RFI #: 30
Date: 1/5/2012
Job: EB-02 Keller Springs Lofts
Phone: 877-777-5115

Subject: Door Schedule

RFI #: 155
Date: 6/13/2012
Job: EB-02 Keller Springs Lofts
Phone: 877-777-5115

Subject: Units with a Mark 17, 18 and 19 Door

2.0a

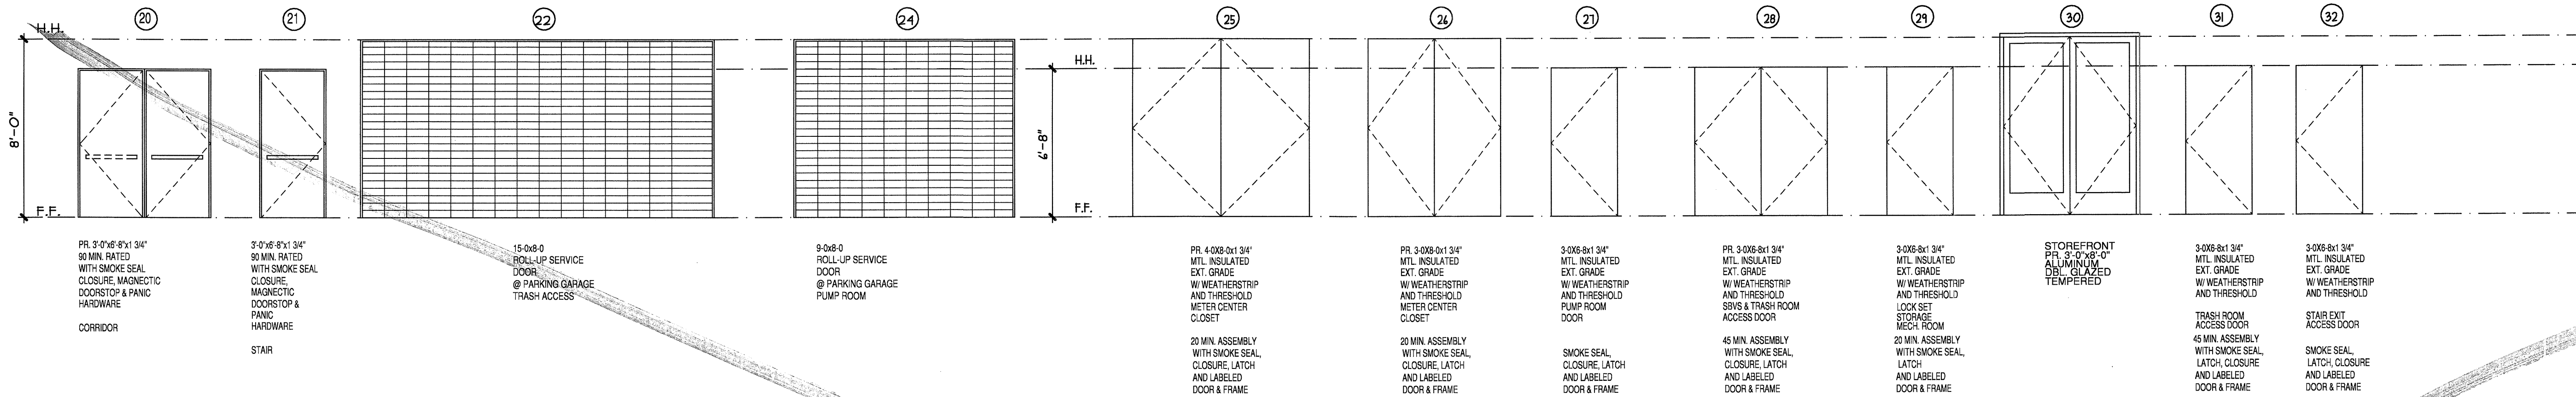
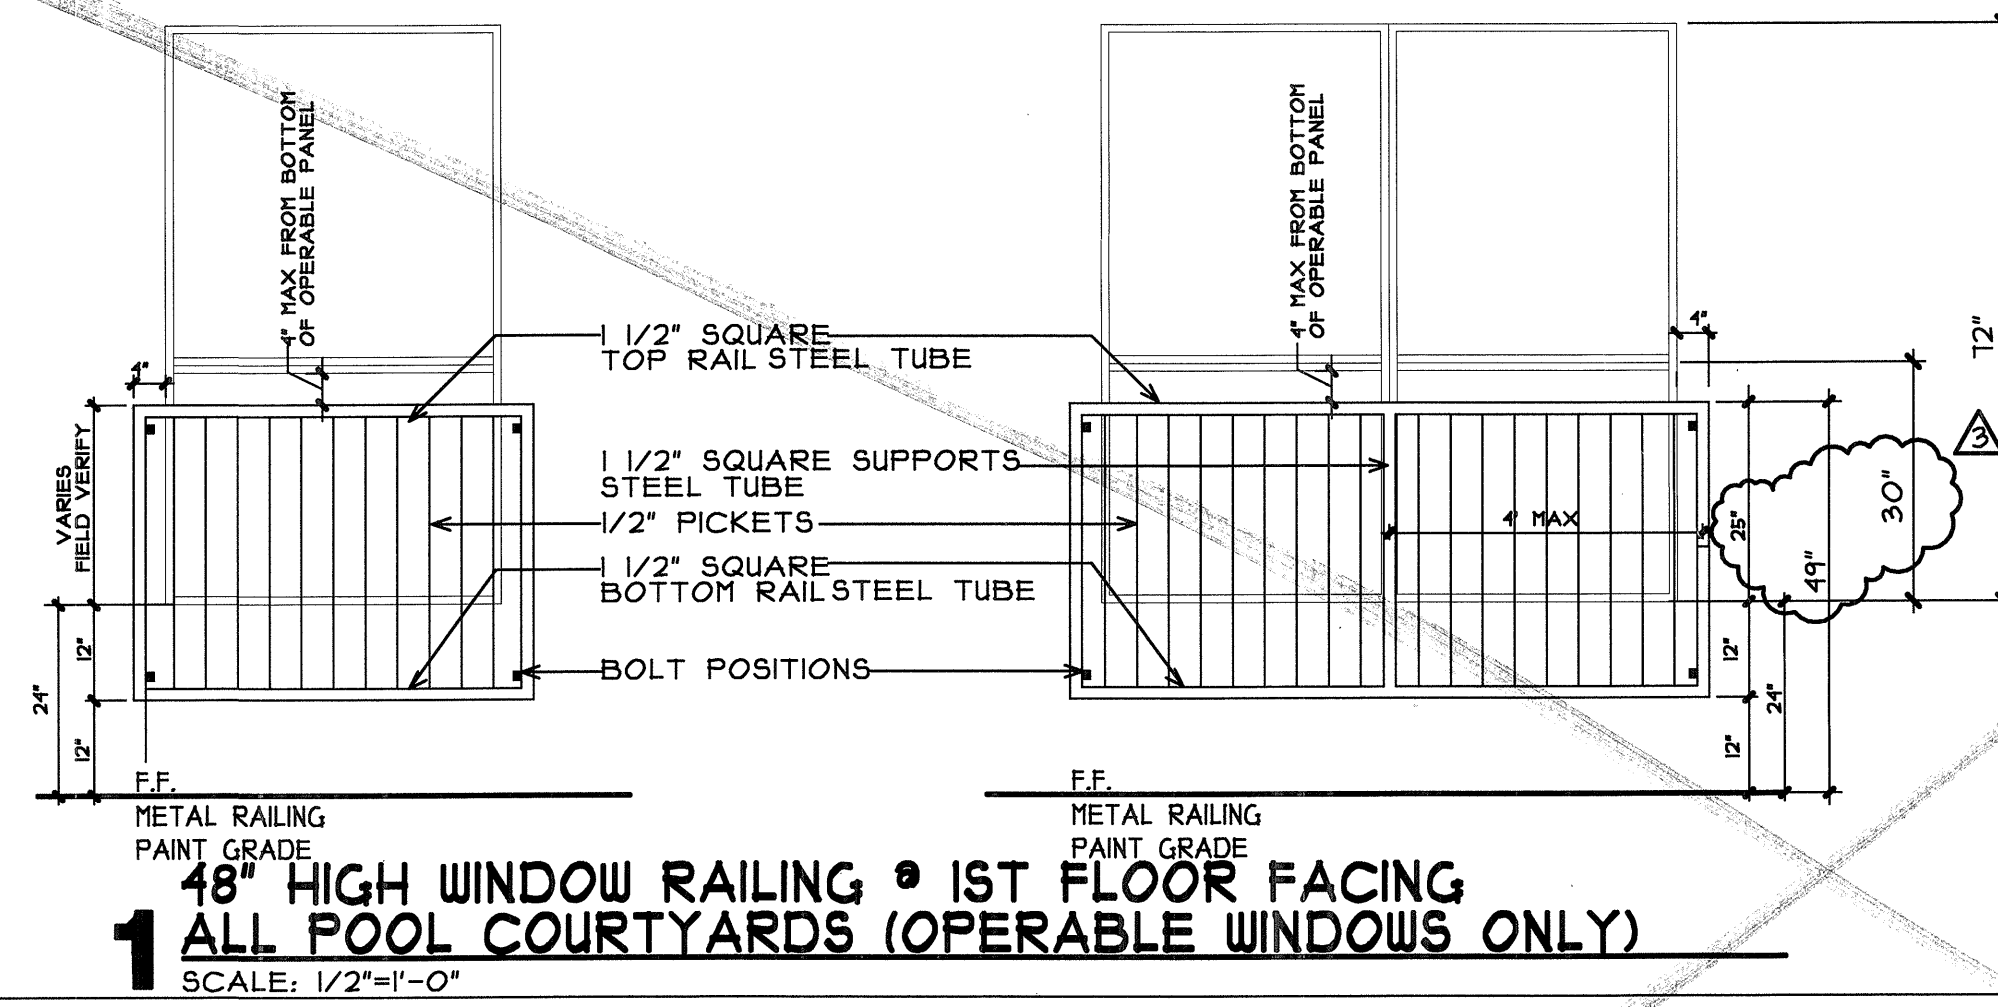
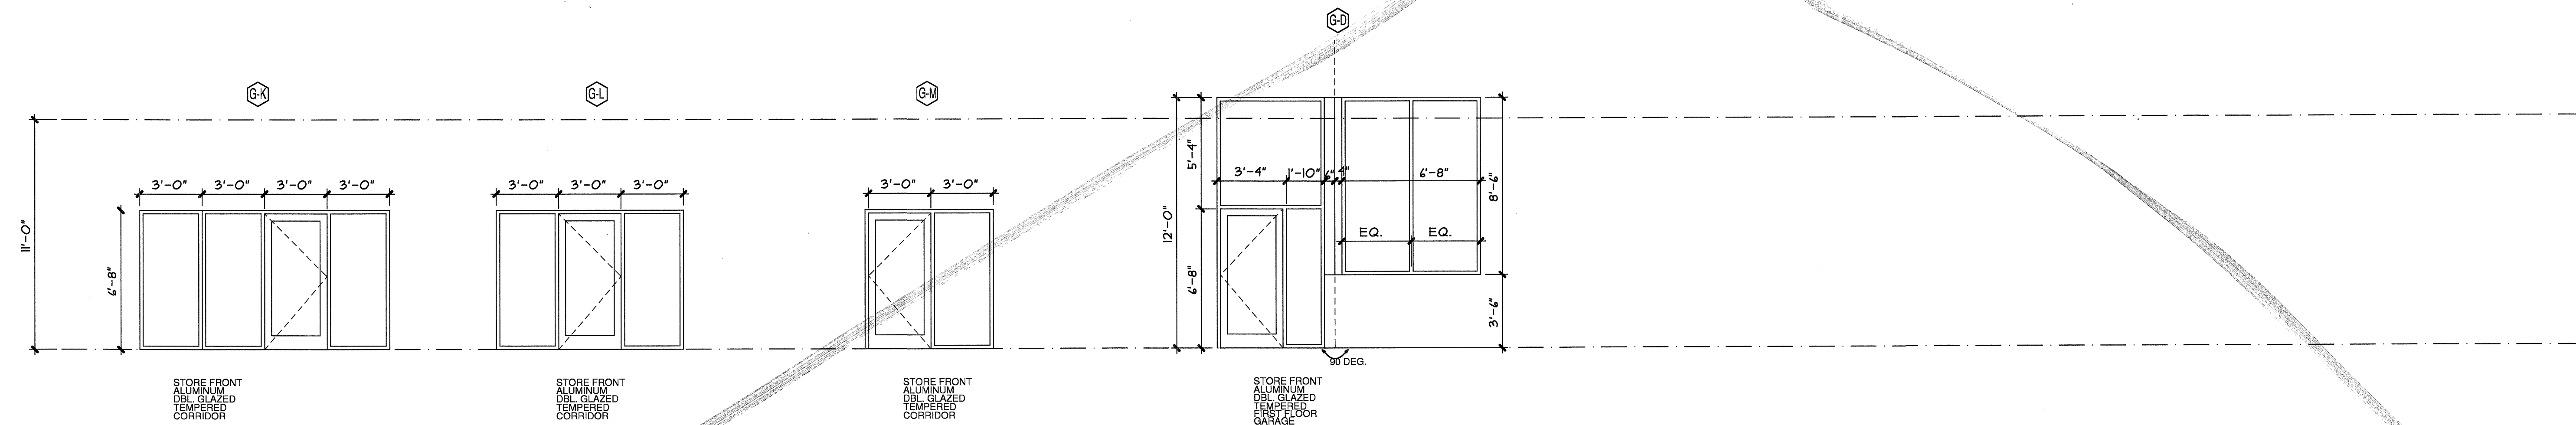
Request: Erik can you provide the door schedule for the common areas doors # 20 and up. **Date Required:** 1/12/2012
Requested by: Bryan Pickler
Embrey Partners, Ltd.

All common door and windows are on sheet 2.0A
within your set

2.0A

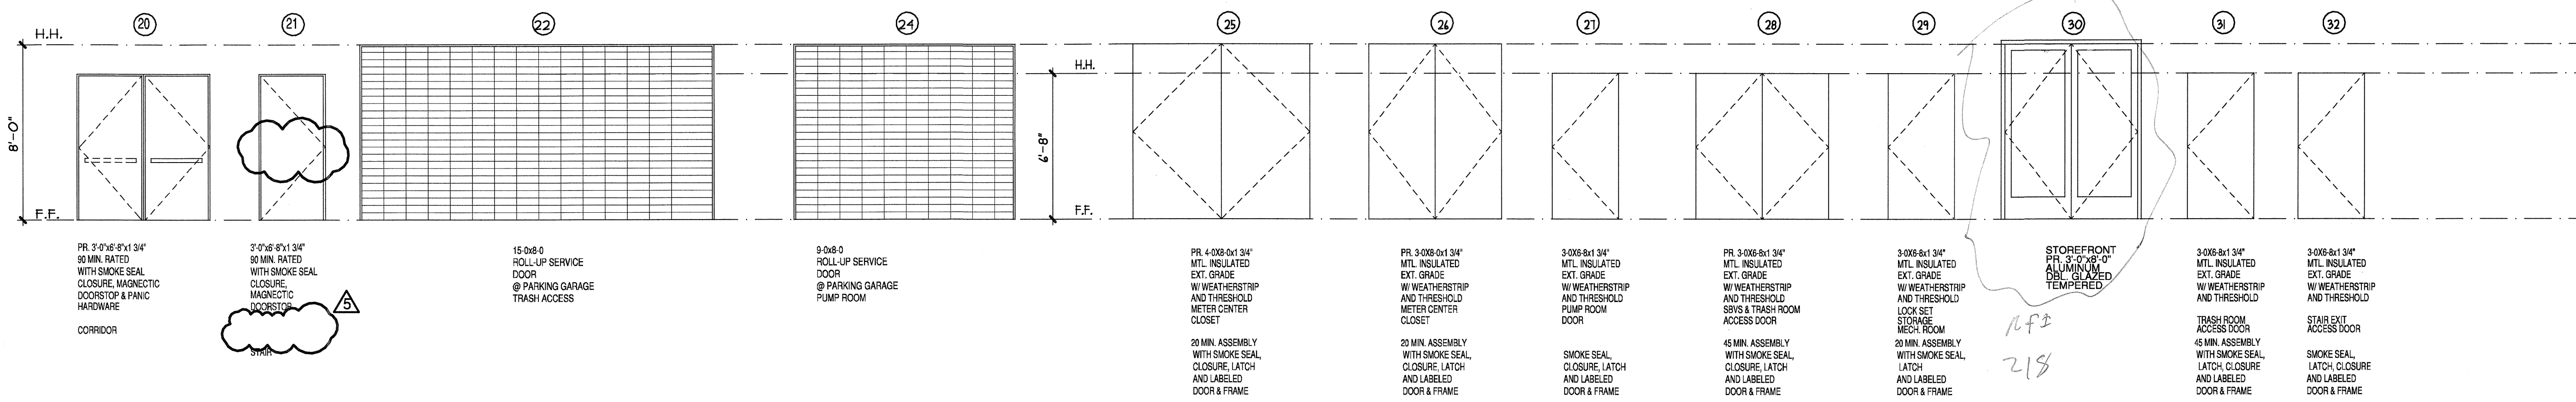
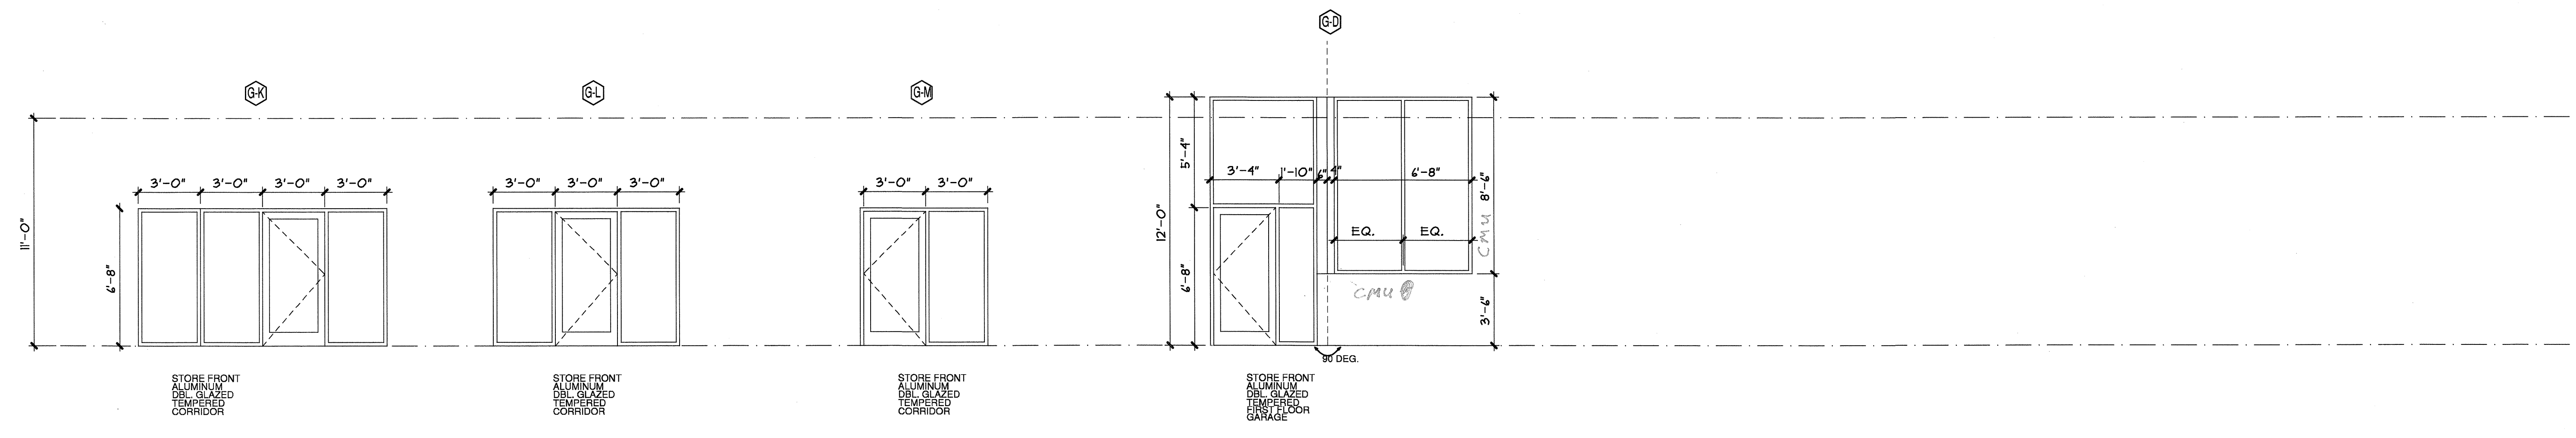
Request: On certain locations where the door 17, 18 and 19 occur, the framing will not allow us to install a door that wide. We propose the following: **Date Required:** 6/20/2012
17 = 2'-8" 3'-0" 2'-8"
18 = 2'-8" 3'-0" 2'-8"
19 = 2'-8" 2'-8" 3'-0"
Requested by: David Miller
Embrey Builders LLC

Response:
I agree.
See revised Version 2.0 that is attached
